**KIRKLEES METROPOLITAN COUNCIL
INVESTMENT & REGENERATION SERVICE**

DELEGATED DECISION TO DETERMINE PLANNING APPLICATIONS

Reference No: 2021/62/91164/W
Site Address: 24a, Stoney Lane, Taylor Hill, Huddersfield, HD4 6HP
Description: Erection of single and two storey extensions
Recommending Officer: Ellie Worth

Project:	Side and Rear Extension 24a Stoney Lane, Taylor Hill, HD4 6HP	Title:	Proposed Site Plan	Drg No:	SL04.#	Scale:	1:200	Date:	Mar 2021	Status:	Planning
----------	--	--------	--------------------	---------	--------	--------	-------	-------	----------	---------	----------

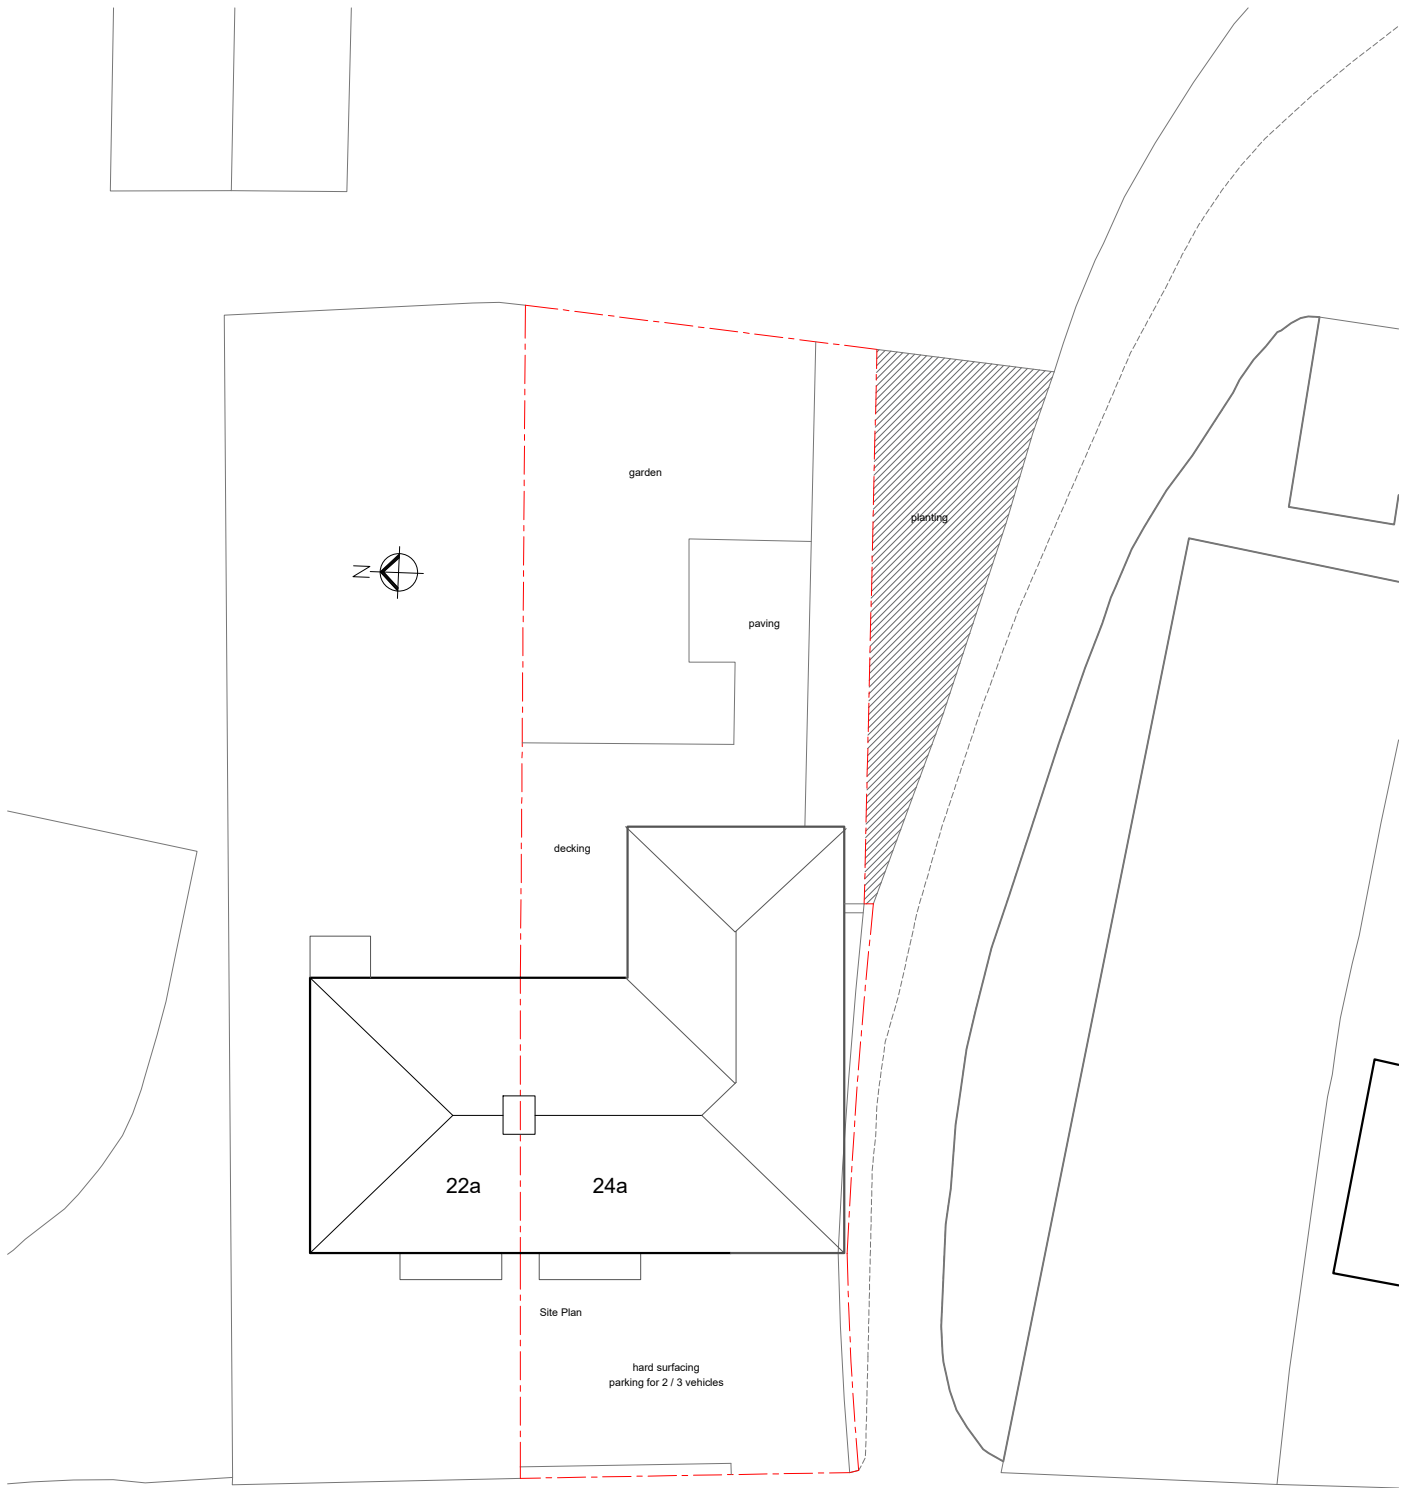
Whilst it has been noted that the works would not intensify the number of bedrooms at the site, the side extension would be built over part of the existing driveway. As such, the proposed block plan states that the existing front garden would be replaced with on site parking. This has been considered acceptable, as sufficient space would be retained for two vehicles.

5. The hereby approved vehicle parking area as shown on the proposed site plan (dwg. no SL04 Rev A) shall be surfaced and drained in accordance with the Communities and Local Government; and Environment Agencies 'Guidance on the permeable surfacing of front gardens (parking areas)' and thereafter retained.

Drg No:
SL05.A

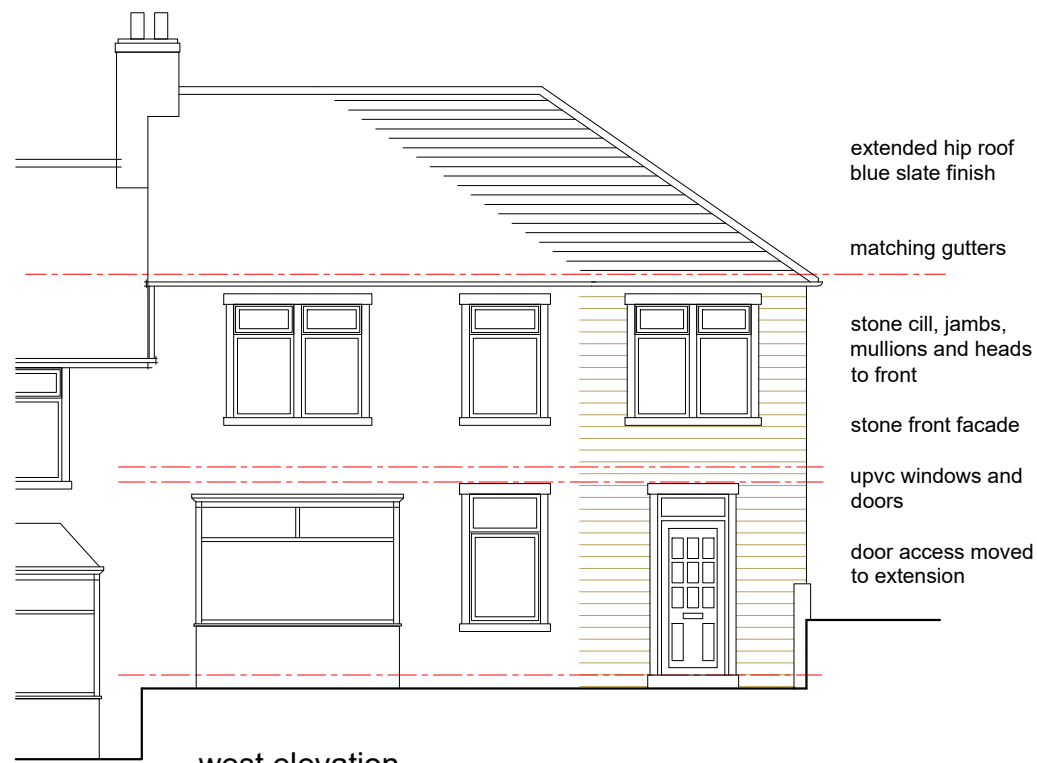
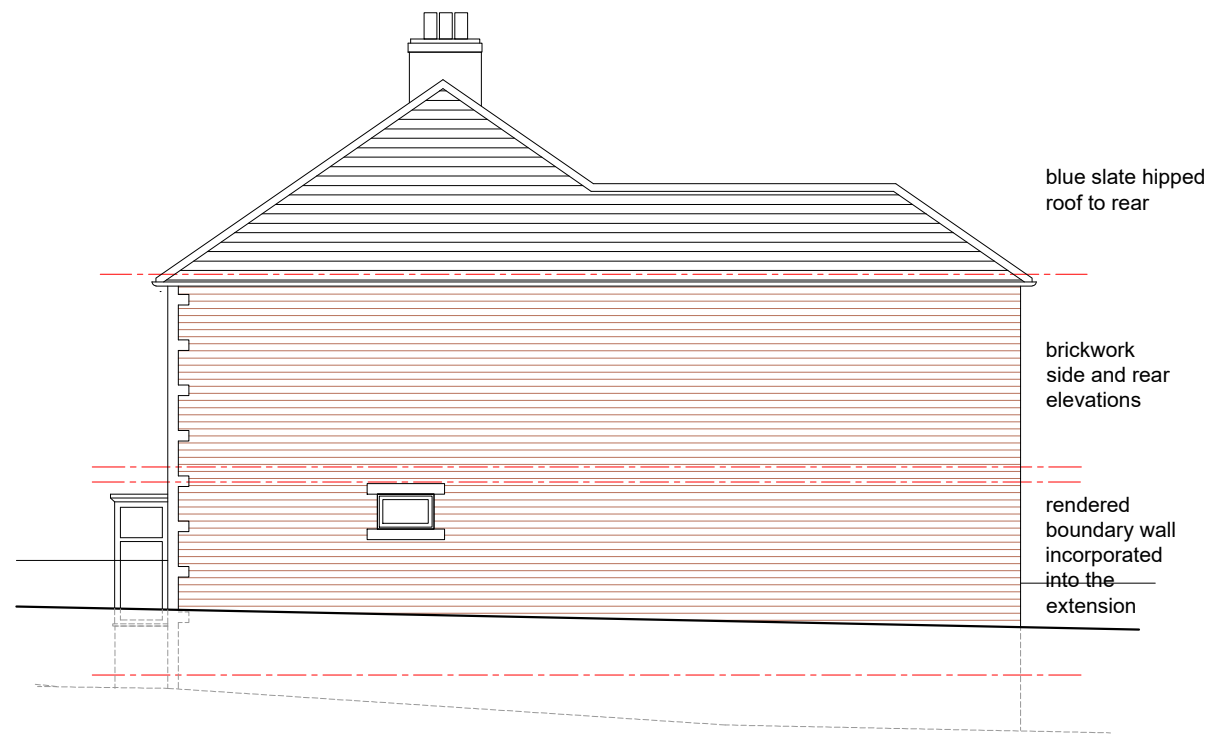
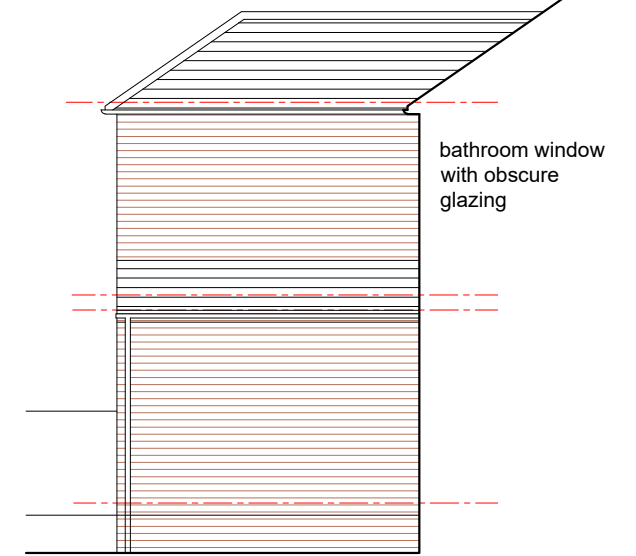
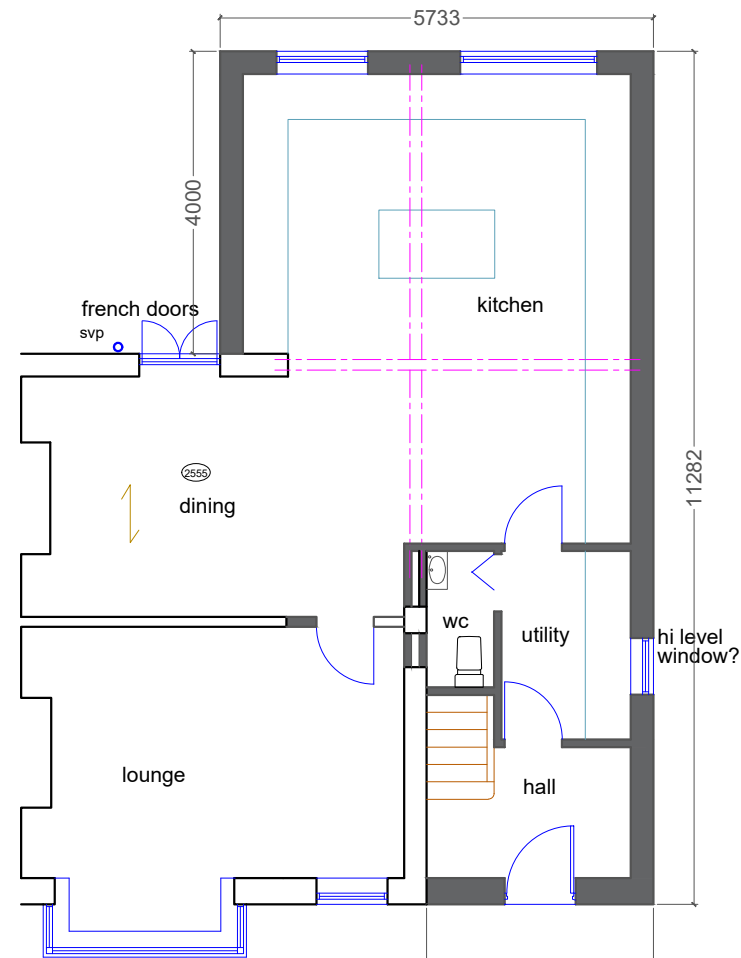
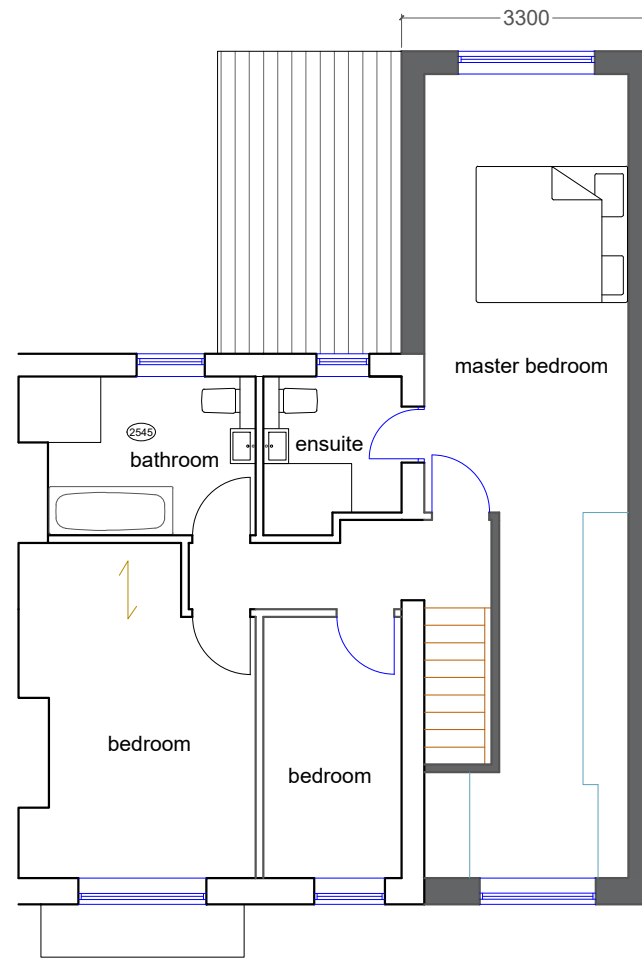
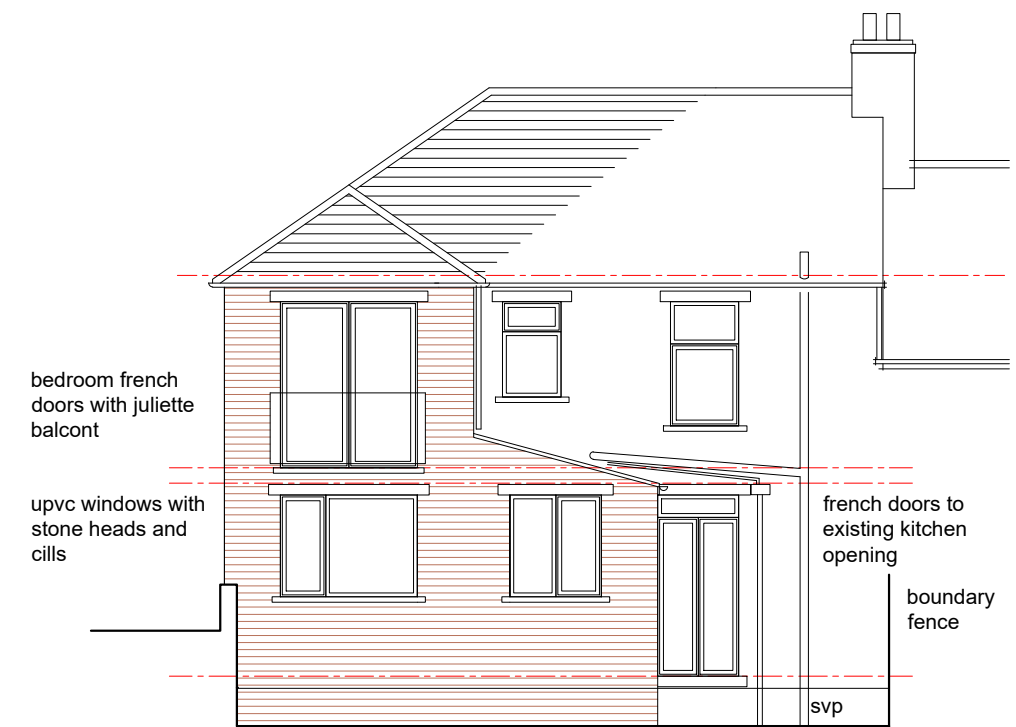
Officers entered into discussions with the applicant regarding the bulk and massing proposed as part of the rear extension. In this case, concern was raised regarding the impact on the adjoining property and therefore amended plans have been sought to restrict the width of the two storey structure to 3.3m and to set the roof significantly down from the ridge. These were received on the 14th June 2021 and 25th June 2021.

the amendments sought to reduce the extent of the two storey rear extension and to set this aspect down from the roof ridge line, officers are satisfied that the original dwelling would still sit comfortably within its curtilage. This would alleviate the majority of the concern.

Given the amendments sought, the two storey rear extension would be set down from the main ridge and would benefit from a hipped roof. The single storey addition would also benefit from a lean to in order to enhance its subservience. The materials would be to match the host property and the fenestration would be in keeping with those that already exist.

22a Stoney Lane is the attached property to the north of the application site. Originally concerns were raised regarding the impact in which the built form would have upon these neighbours' amenity including their rear openings. As such, amended plans have been sought to reduce the width of the two storey rear extension and to install a single storey extension nearest to these neighbours' openings. The submitted plans also show the roof pitch for the two storey aspect to be set down from the main ridge and to be hipped. This will reduce a significant amount of overbearing and overshadowing, which is further intensified by the change in levels. As such, officers are satisfied that the main impact would be upon these neighbour's pedestrian door and therefore any harm would not be detrimental.

4. Notwithstanding the provisions of the Town and Country Planning (General Permitted Development) (England) Order 2015 as amended (or any Order revoking or re-enacting that Order) no doors, windows or any other openings (apart from any expressly allowed by this permission) shall be created in the northern facing side elevation of the single storey rear extension hereby approved.
